Able Marine Energy Park

Material Change 2

Answers to ExB's first

Application by Able Humber Ports Ltd for Able Marine Energy Park Material Change 2

Project: ABLE Marine Energy Park  
 Client: ABLE UK Limited  
 Drawing Title: Section A for Quay Typical Section

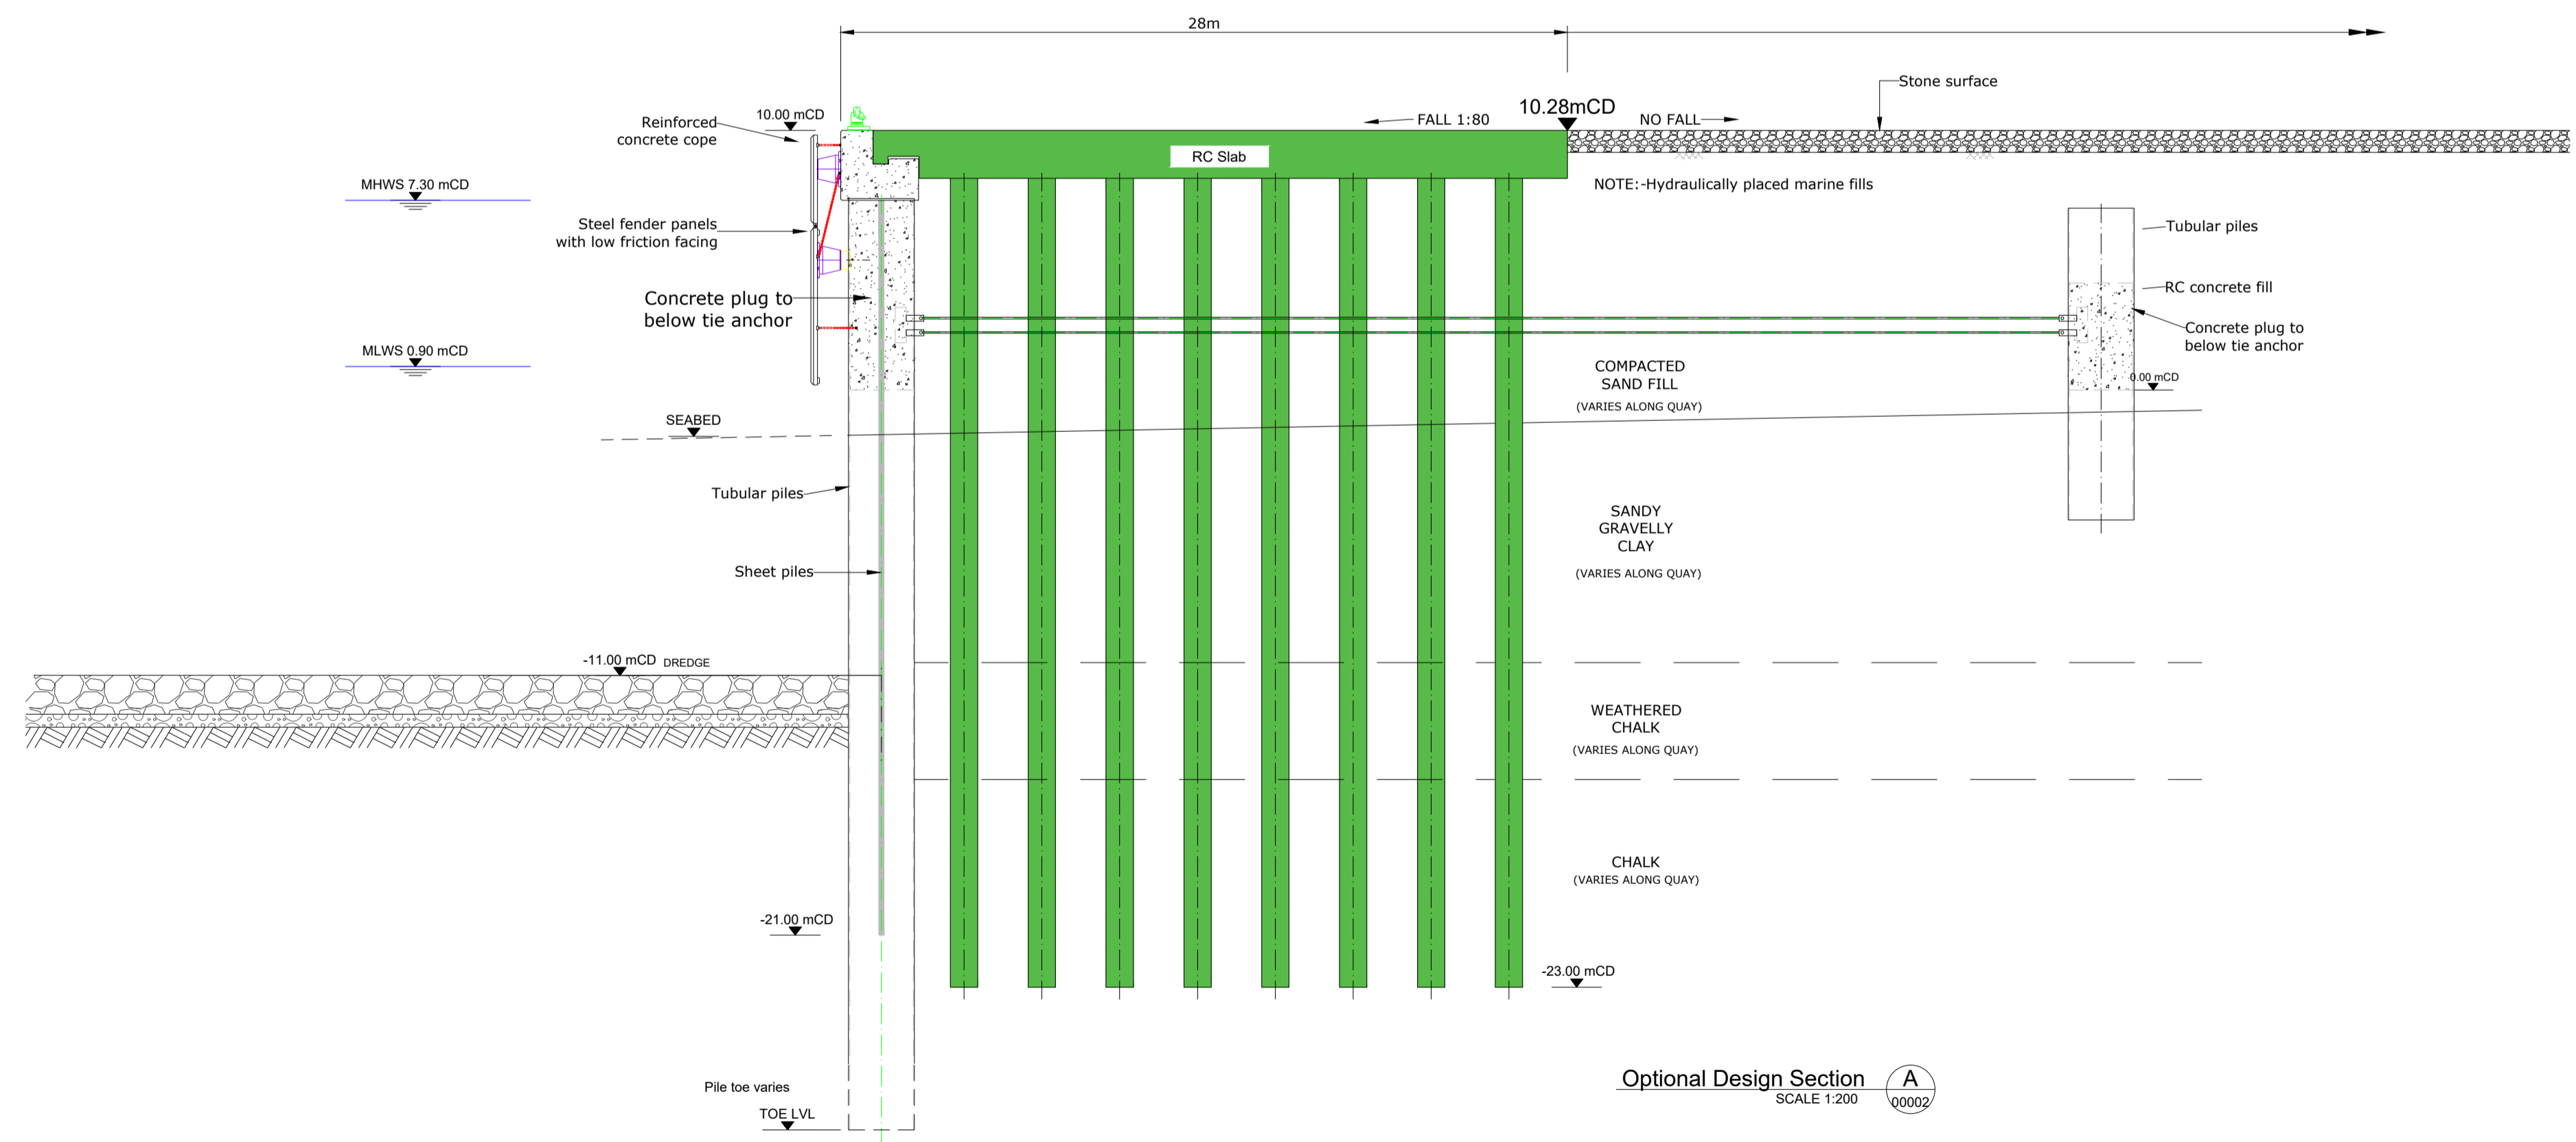
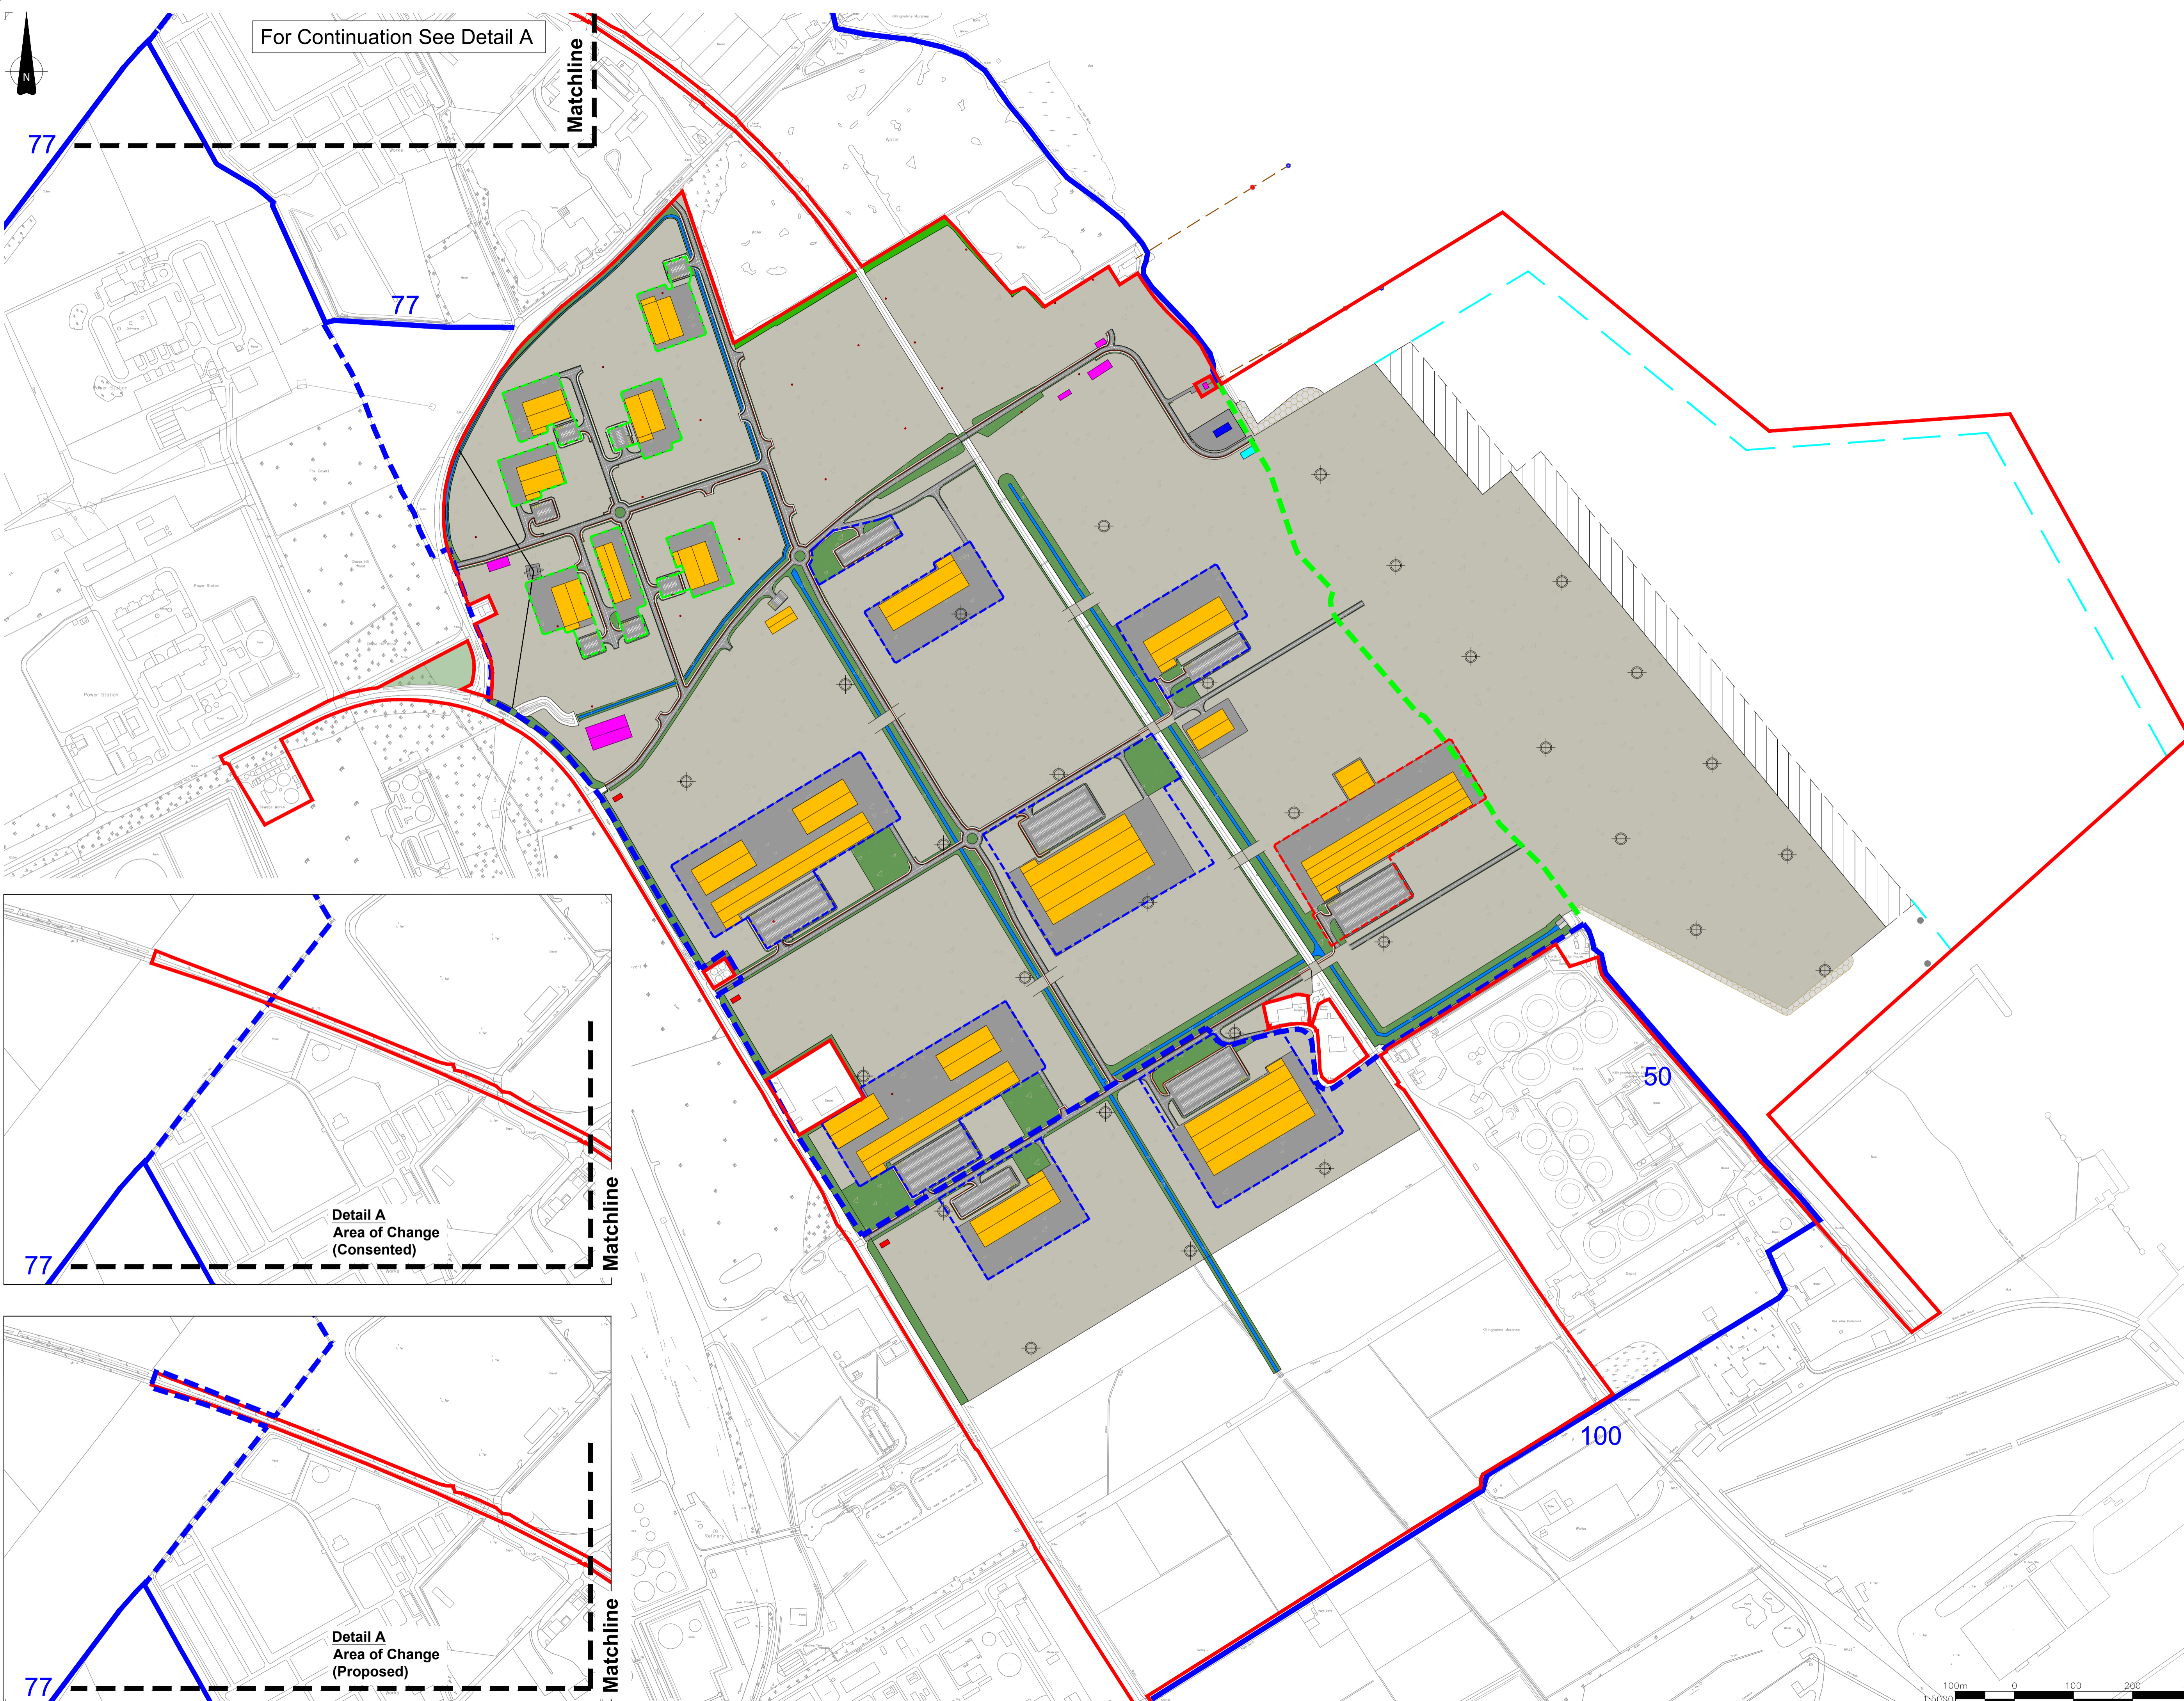
Q1.03	App	<p>Re: drawing AME-036-0003 rev C, no crane rail is shown in the Optional Design Section. Is this because the thicker RC slab would allow flexible crane location?</p> <p>The rail crane has not been designed to date and will only be procured if there is a business case for its installation in the future.</p> <p>The rear crane rail can be expected to be behind the quay rather than incorporated into it. If it is needed, a separate application for the construction of the rear crane rail will be submitted to the LPA once the crane design has been completed.</p>
Q1.04	App	<p>How would the number and diameter of piles vary in the alternative approaches?</p> <p>General The material change is expected to reduce the number of quay piles as the specialist berth in now omitted and that feature required extensive perimeter piling.</p>
